Application number: 2025/92638	
What is the application for?:	Erection of side and rear extensions with hardstanding to front elevation
Address of the site or building:	6, Ashbourne View, Cleckheaton, BD19 5JE
Postcode:	BD19 5JE

Type of comment: An objection	
Do you wish your comments to be published on the website anonymously?	Yes
<p>Planning Department Kirklees Council Planning Services Civic Centre 3 Market Street Huddersfield HD1 2YZ</p> <p>Subject: Objection to Planning Application – Proposed Extension at 6 Ashbourne View, Cleckheaton 2025/92638</p> <p>Dear Sir or Madam,</p> <p>I am writing to formally object to the proposed extension at 6 Ashbourne View, Cleckheaton, on the following material planning grounds.</p> <p>1. Loss of Light and Overshadowing</p> <p>The proposed extension would extend approximately 4.2 metres beyond the existing building line, resulting in significant loss of natural light and increased overshadowing to my property at 4 Ashbourne View. This would materially reduce daylight to the rear rooms and garden area, contrary to Policy LP24 (Design) of the Kirklees Local Plan, which requires developments to ensure adequate levels of amenity for neighbouring p

Drawing Title
 PROPOSED

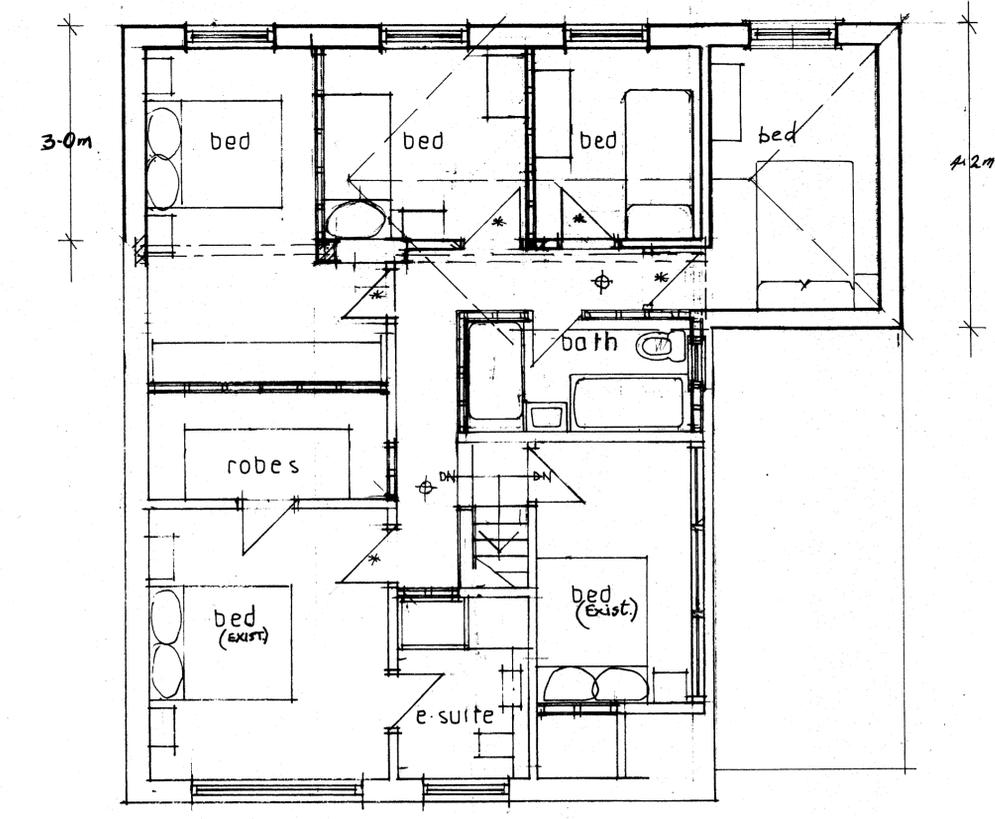
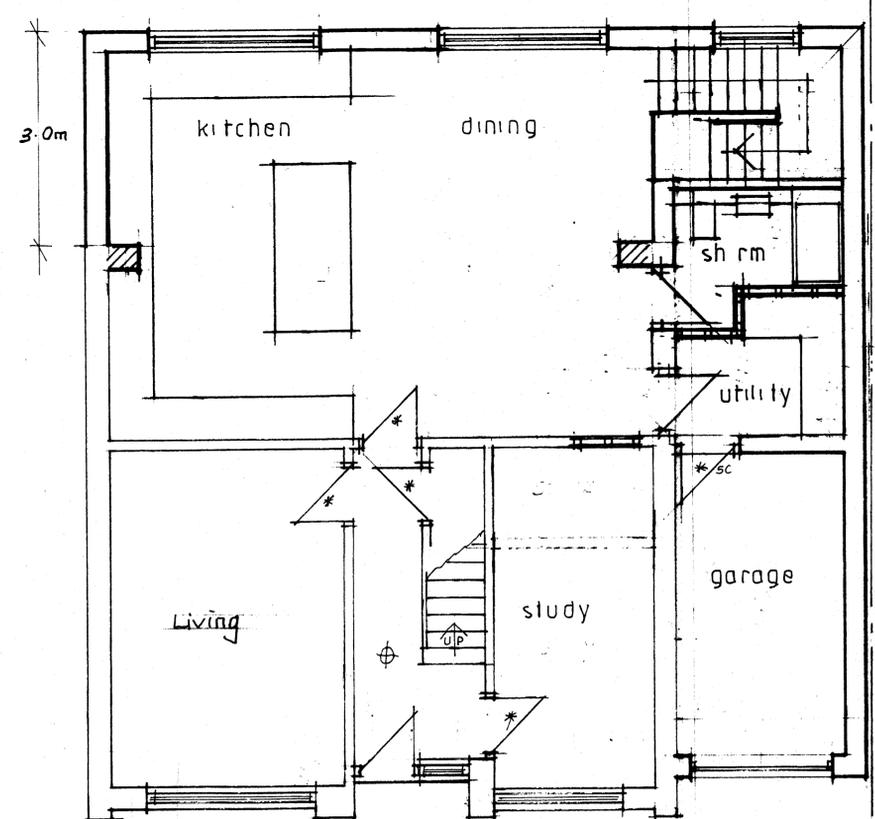
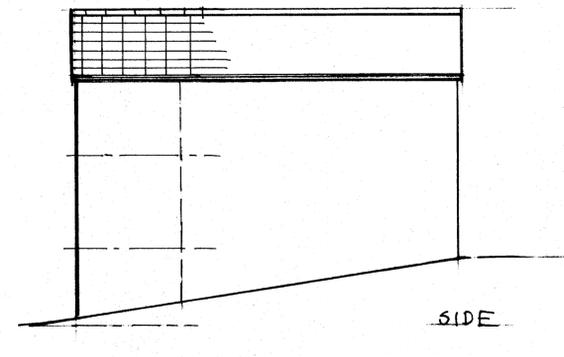
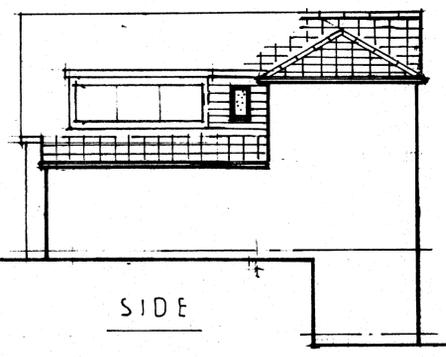
The proposed extension would create windows and elevated views directly overlooking my garden, resulting in a significant loss of privacy. This would adversely affect the enjoyment of my home and garden, contrary to LP24 (Design) and paragraph 130(f) of the National Planning Policy Framework (NPPF), which seek to ensure developments create a high standard of amenity for existing and future occupants.

Taken together, the excessive scale, projection and proximity of the proposed extension would have a detrimental impact on residential amenity, in terms of light, privacy and outlook. The development would therefore fail to respect the character and relationship between neighbouring properties, conflicting with Local Plan Policy LP24(a) and (b).
